Comments on the Applicant's D5 Submissions

This document sets out the comments by Cambridgeshire County Council (**CCC**) and Fenland District Council (**FDC**) (together, **the Councils**) on the Applicant's Deadline 5 (**D5**) submissions. The tables below set out the document in question that the Councils are commenting on, together with the relevant paragraph or reference number.

2.4 Access and Rights of Way Plan - Revision 5.0 [REP5-004]

APFP REGULATIONS: 5(2)(k)

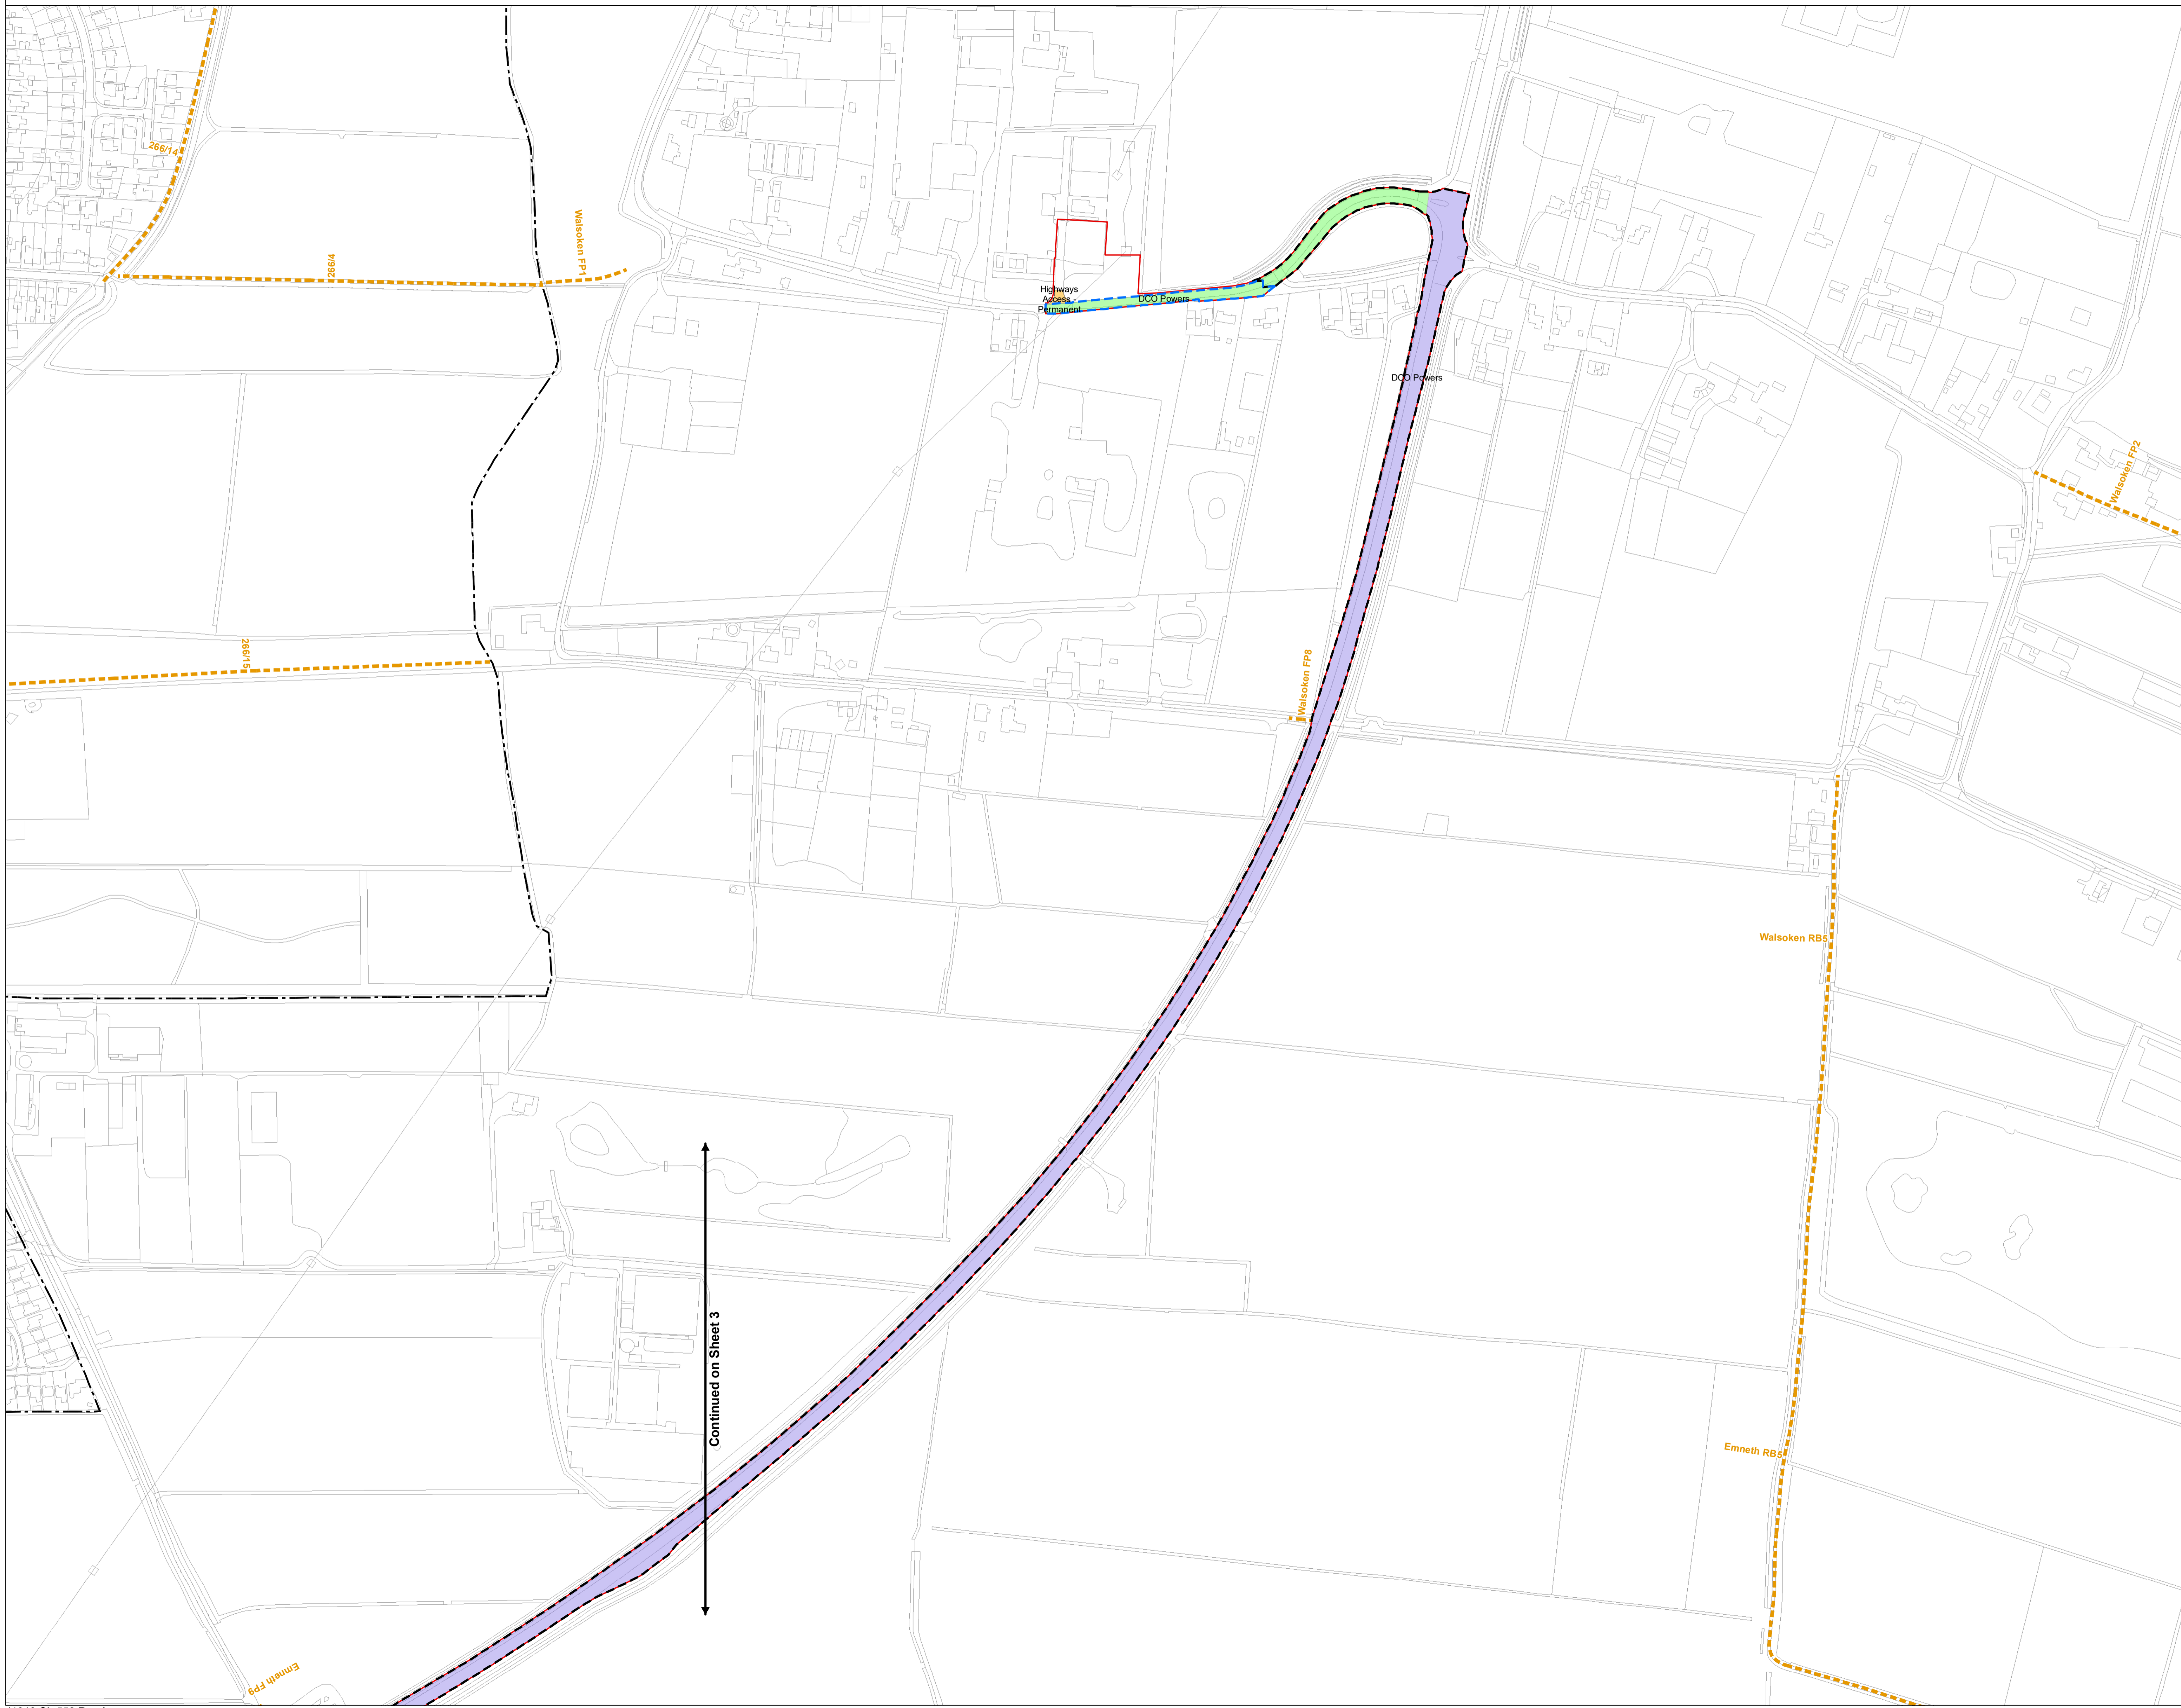
Topic	Paragraph Number	Councils' Comment
Boundaries of local highways	All plans	This version of the Access and ROW Plans appears to have been superseded by the change application submitted by the Applicant, which seeks to broaden the DCO boundary at the junctions of New Bridge Lane with both Cromwell Road and Salter's Way. Accordingly, the highway boundaries within the Order Limits would, if the Change Application is accepted, require to be updated to reflect the larger area of highway that is required to work within.
Boundaries of local highways	Plan 1 of 4	Following the discovery by CCC of new information about the highway boundary at the junction of Cromwell Road and New Bridge Lane, CCC and the Applicant have been in liaison about the effect this information has on the highway extent that is available for the Applicant to work within. This revised extent is reflected in the Applicant's Change Application documents, but is not shown on this version of the Access and ROW Plans.
